Your Ref 75111/APP/2025/739

Our Ref CRTR-PLAN-2025-44006

Proposal: Redevelopment of site to deliver extension to existing Union Park data centre campus consisting of (a) free standing data centre building (b) energy, power, and water infrastructure (c) site access and internal roads (d) site security arrangements (e) hard and soft, green landscaping and (f) other ancillary and auxiliary forms of development

Location: Union Park UP4, North Hyde Gardens, Hayes

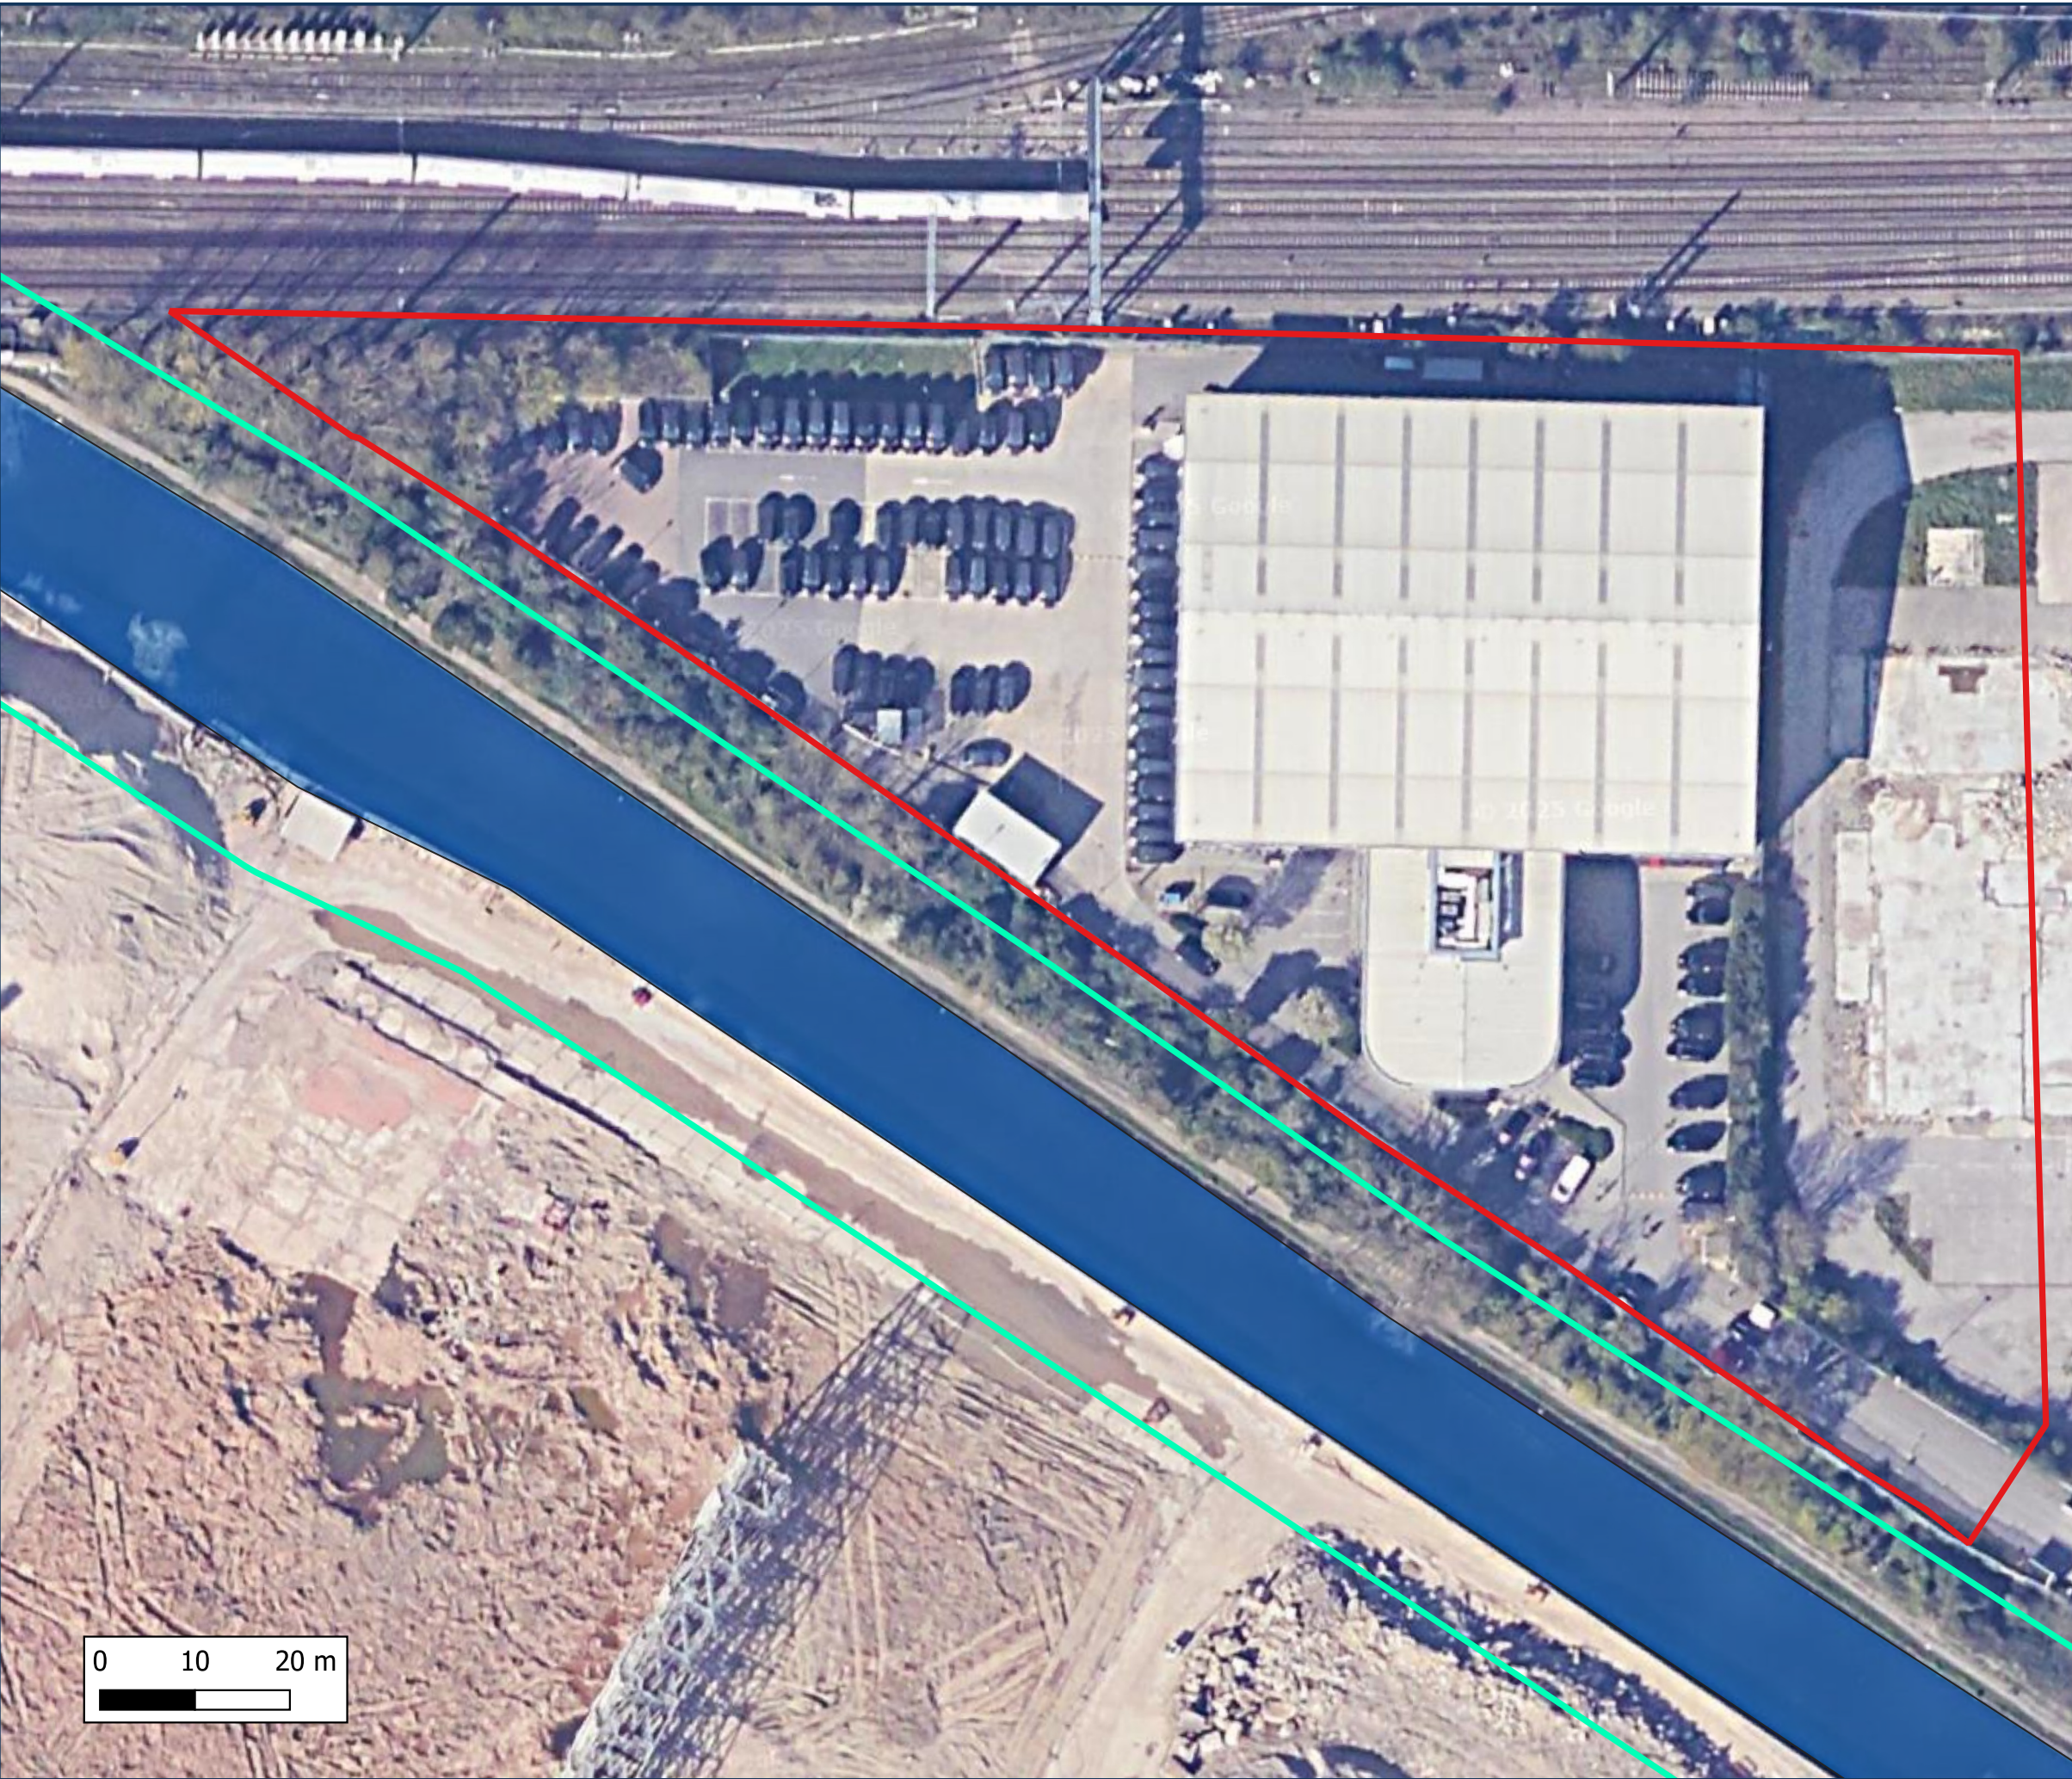
The BNG report states that the site boundary is more than 10m from the riparian zone of the Grand Union canal and therefore concludes that the inclusion of watercourse units is not applicable. However, there seems to be some contradictions on this matter within the submitted reports. The Ecological Enhancement Scheme states, *"The site boundary extends southwards slightly in the northwest, meaning that the canal is six metres from the site boundary at its closest point."* This should mean that enhancements to improve the condition of the watercourse should be undertaken by the applicant due to the riparian zone being within 10m of the canal.

The applicant/developer should therefore provide some clarity on this matter and confirm the application's distance from the watercourse. There also seems to be a small strip of land which is within the applicant's ownership which has not been included within the red line site area and clarification on this should also be provided. The Trust wish to be consulted on any further information when available.
